From: Contact Centre (CRM) <contact@ribblevalley.gov.uk>
Sent: 28 June 2022 13:53
To: Planning
Subject: Planning Application Comments - 3/2022/0440 FS-Case-432901638

Planning Application Reference No.: 3/2022/0440

Address of Development: 1 Park Road, Gisburn, BB7 4HT

PLAN & ELEVATIONS OF GARDEN ROOM/OFFICE & STORE FOR
MR & MRS P HARGREAVES 1 PARK RD GIBURN

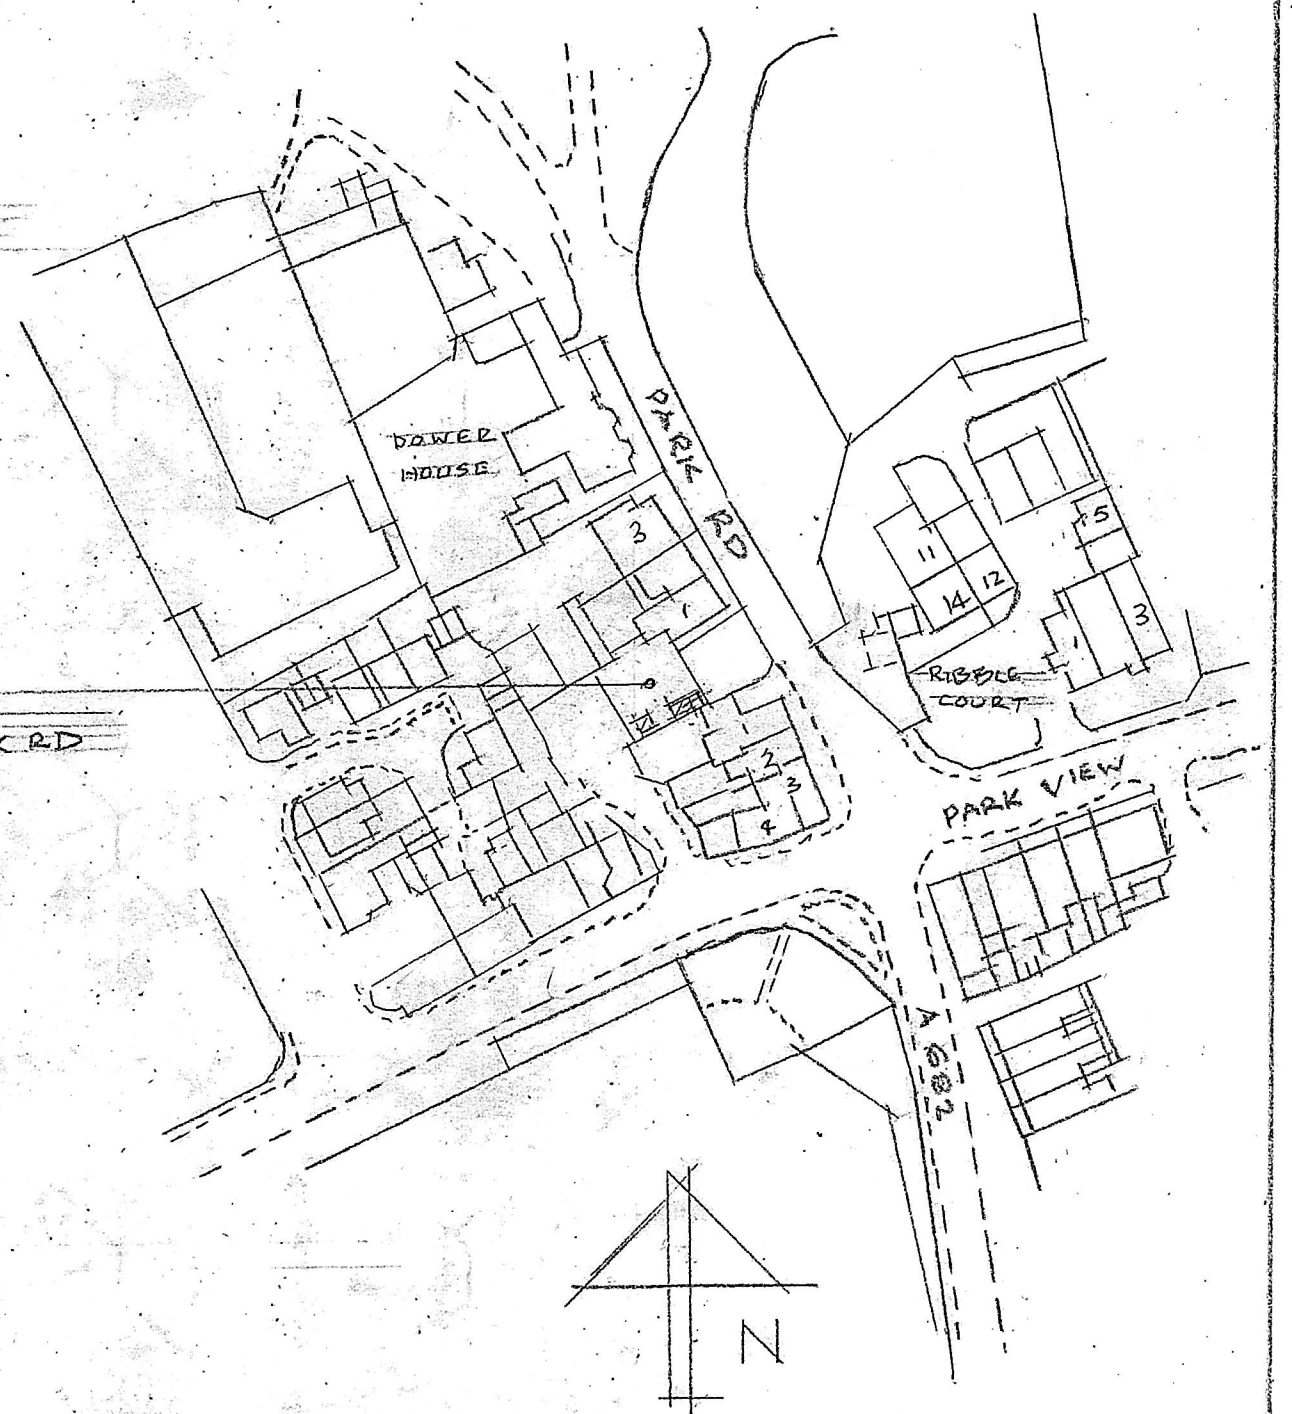
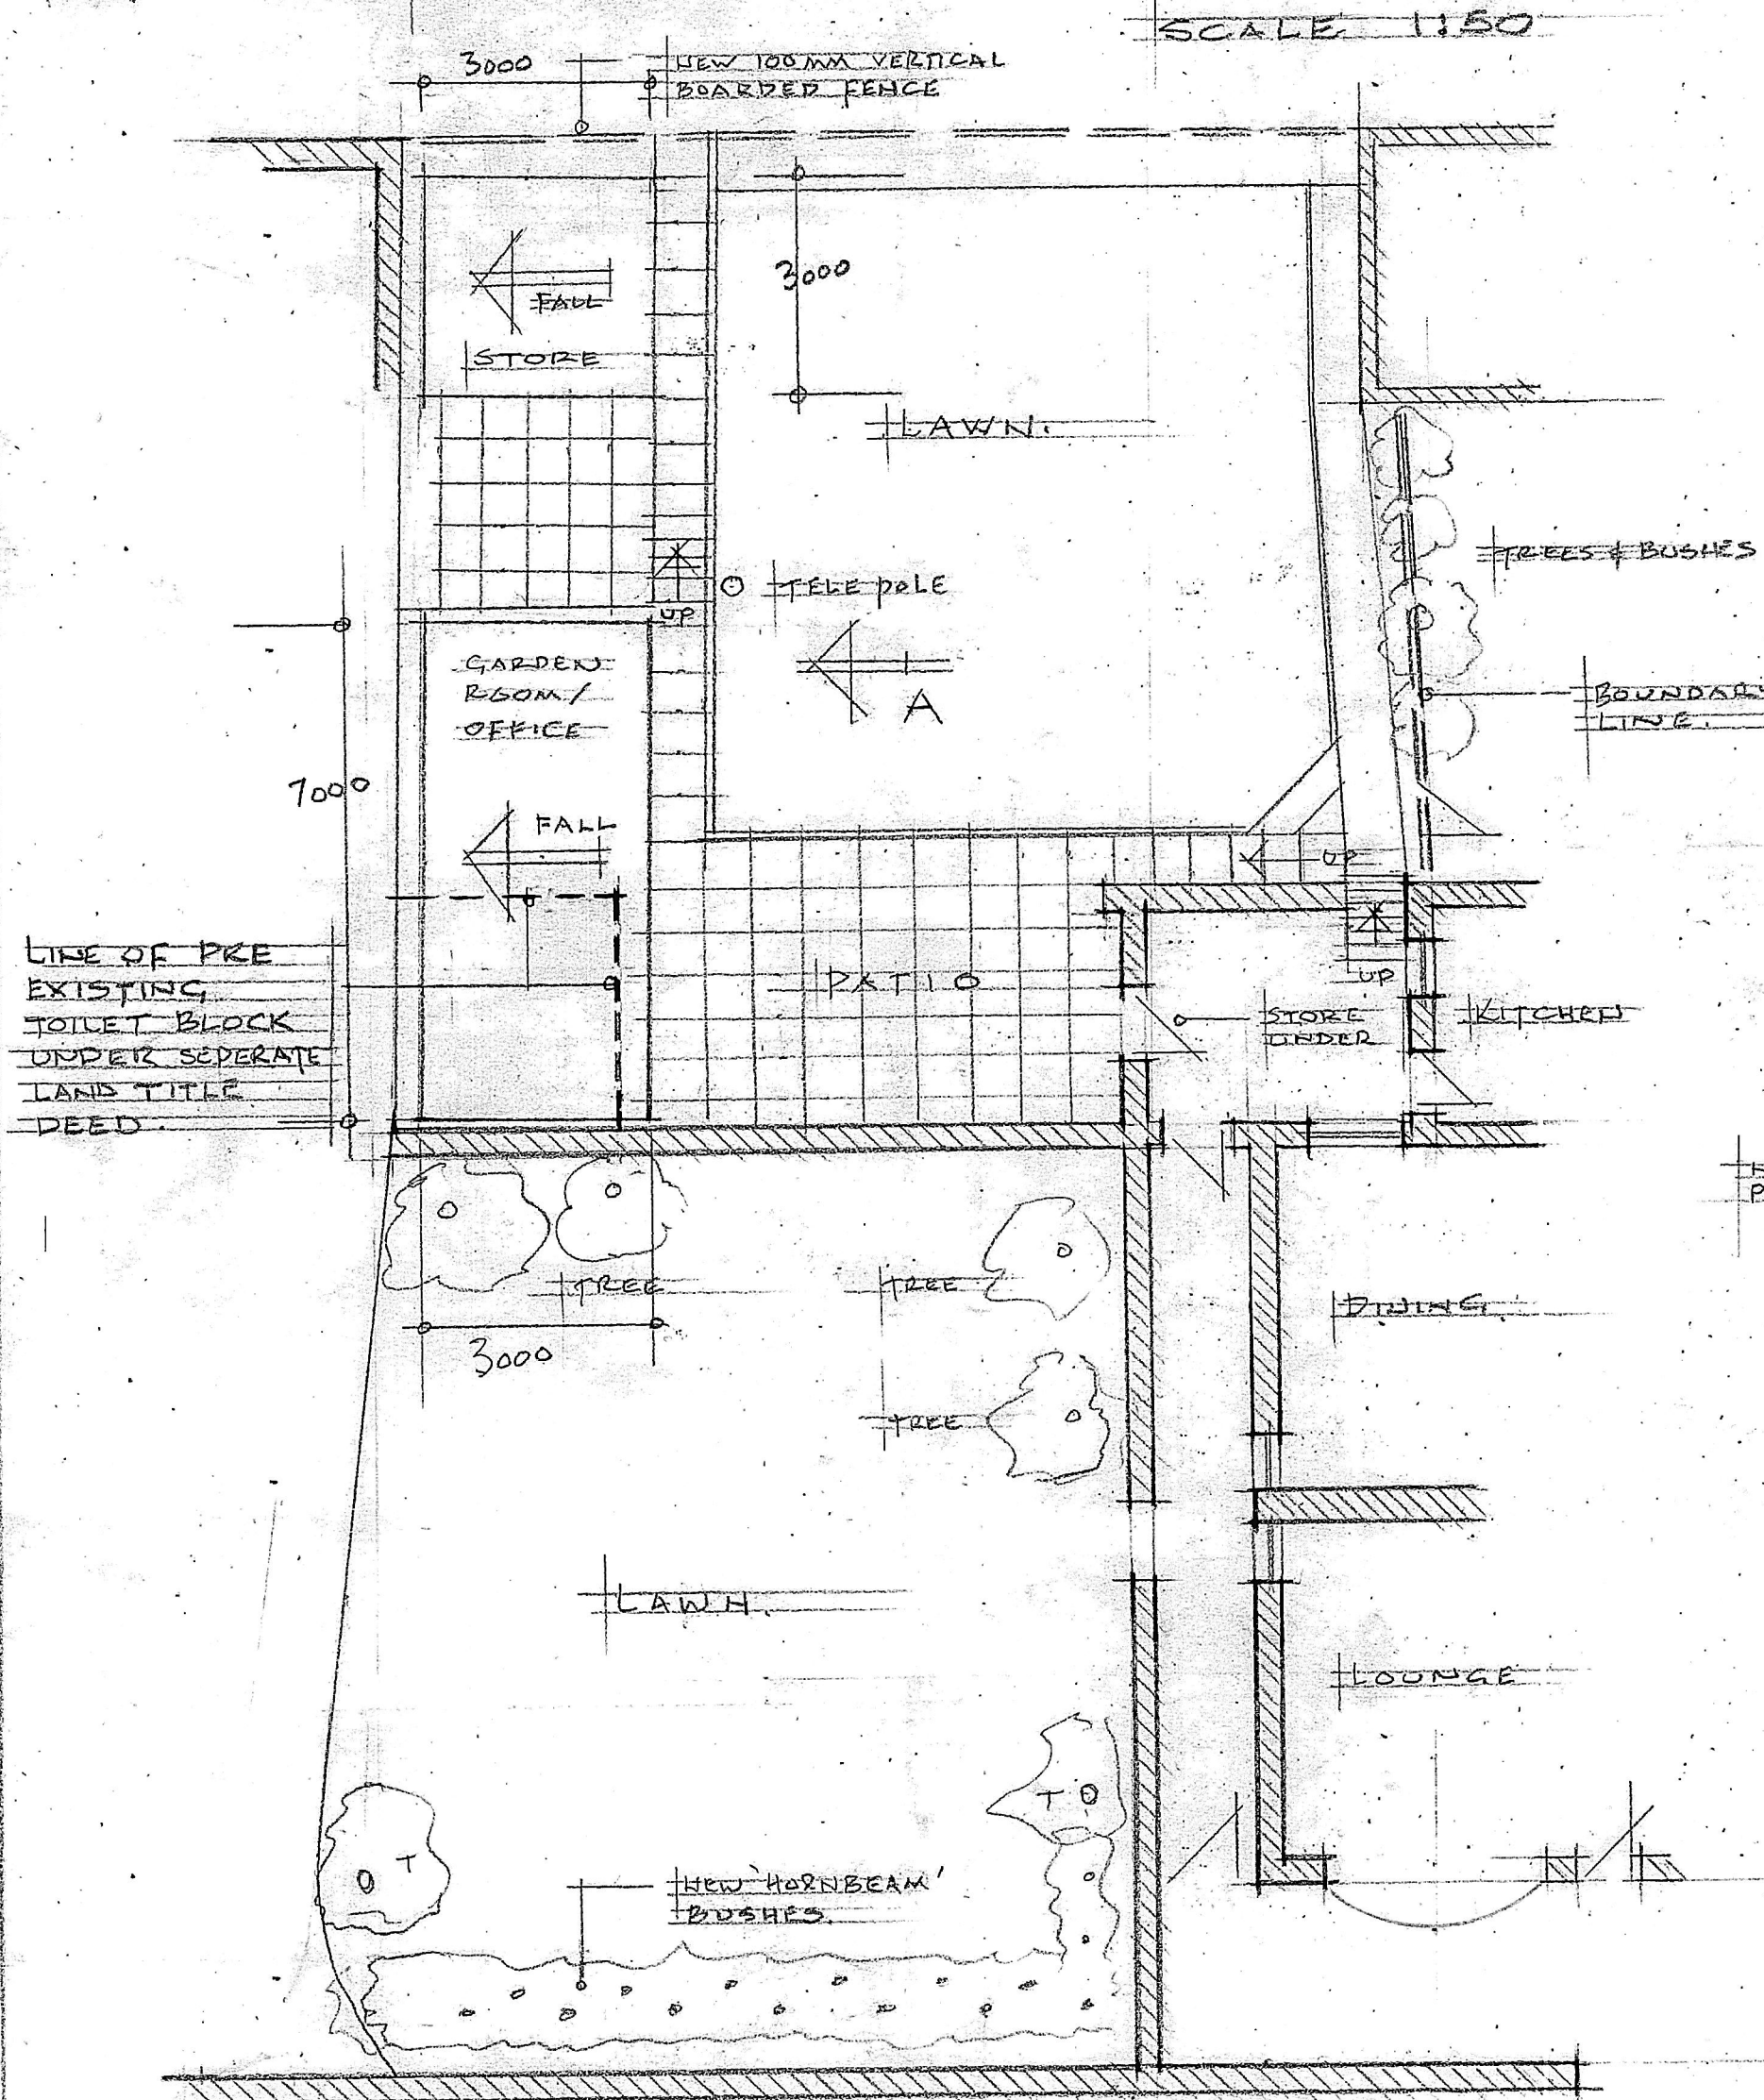
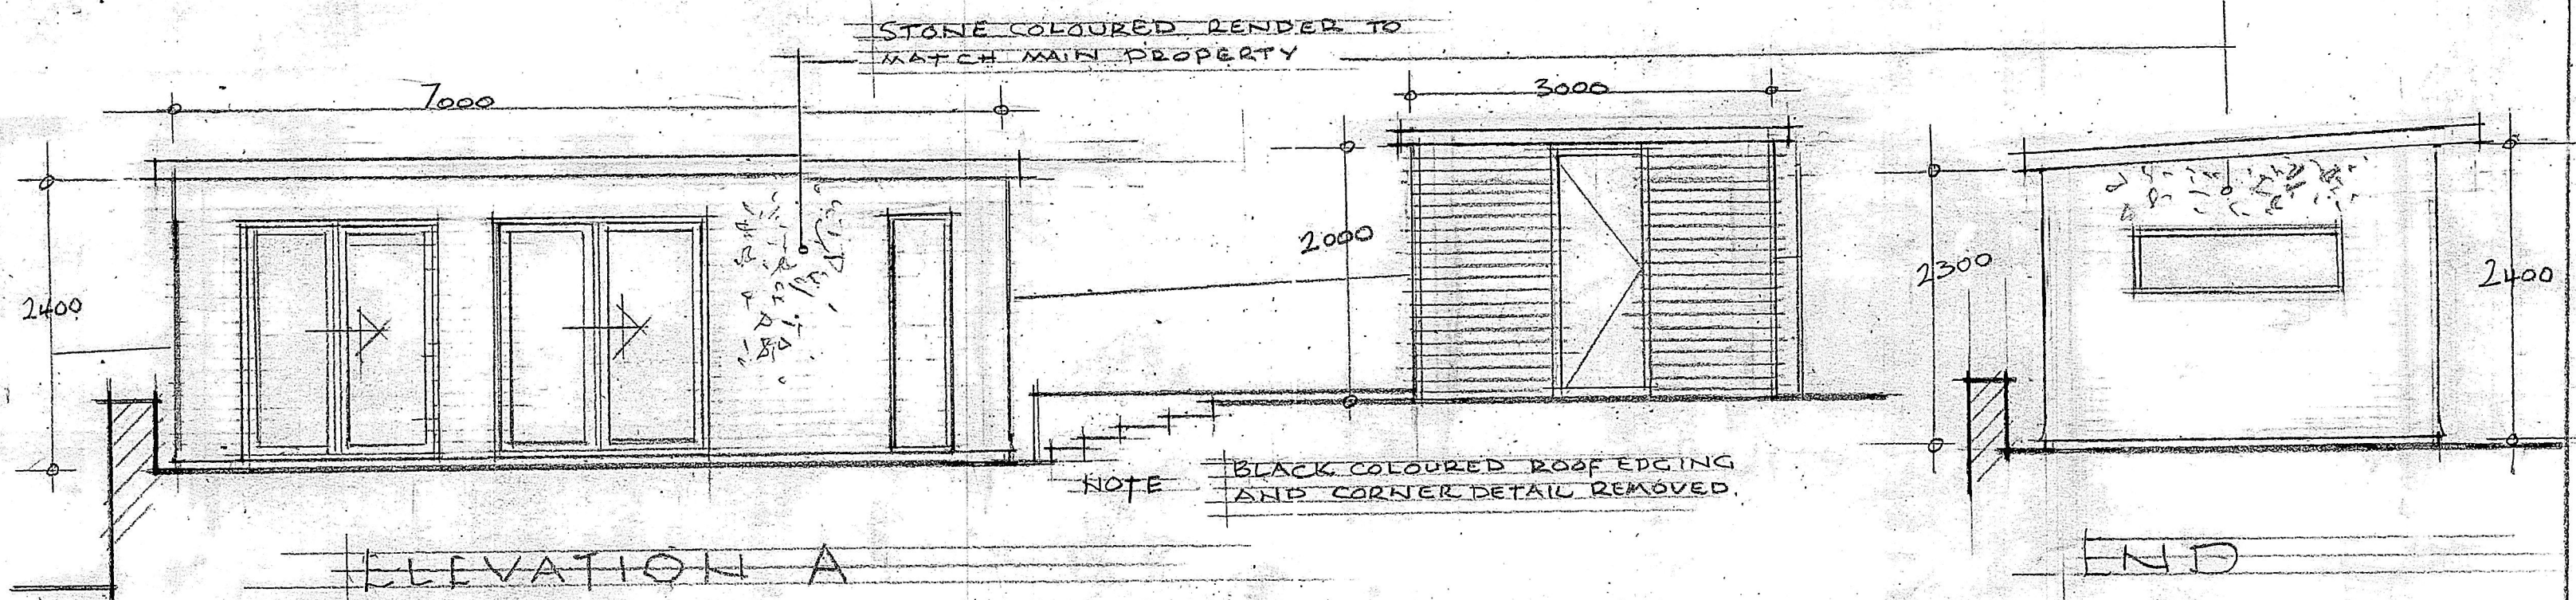
Addressing paragraph 8 in the appeal decision, "the roof detailing and corner detailing (are) cumbersome" I understand that according to the planning statement "it is proposed to remove the black trim from the roofline of the garden office and the shed" but this does not address the black corrugated roof which is clearly visible from the view mentioned above by the A59 approaching Gisburn and by No.'s 1-6 Park Mews. The planning statement also proposes to "change the exterior of the North and East facing elevations of the outbuildings to a more sympathetic stone coloured render to blend in with the main dwelling" this being No. 1 Park Road. This does not address the South facing elevations which effect the view from No.'s 1-6 Park Mews. I assume these elevations will remain unaltered.

The buildings will remain the same size, and therefore dominate the landscape from various viewpoints. Paragraph 4.5 of the planning statement suggests that the proposed changes in the submitted plans will effect "a more sympathetic design and scale for the outbuildings" but the scale remains the same, it also mentions the "fleeting views of the site from Park Mews". The view is not "fleeting" from the six properties of Park Mews, it is constant.

Paragraph 4.6 states that "it is proposed to incorporate vines on the walls of the garden office, which will further break up the visual impact" but it fails to state on which aspect of the walls these vines will grow, and there would be no room to plant any vines on the South elevation of the walls of the office or garden shed as they are built too close to the boundary wall with No 1 Park Mews. Therefore the visual impact from the south elevations and Park Mews No's 1-6, the A59, the cenotaph and playing fields would remain the same as it does now.
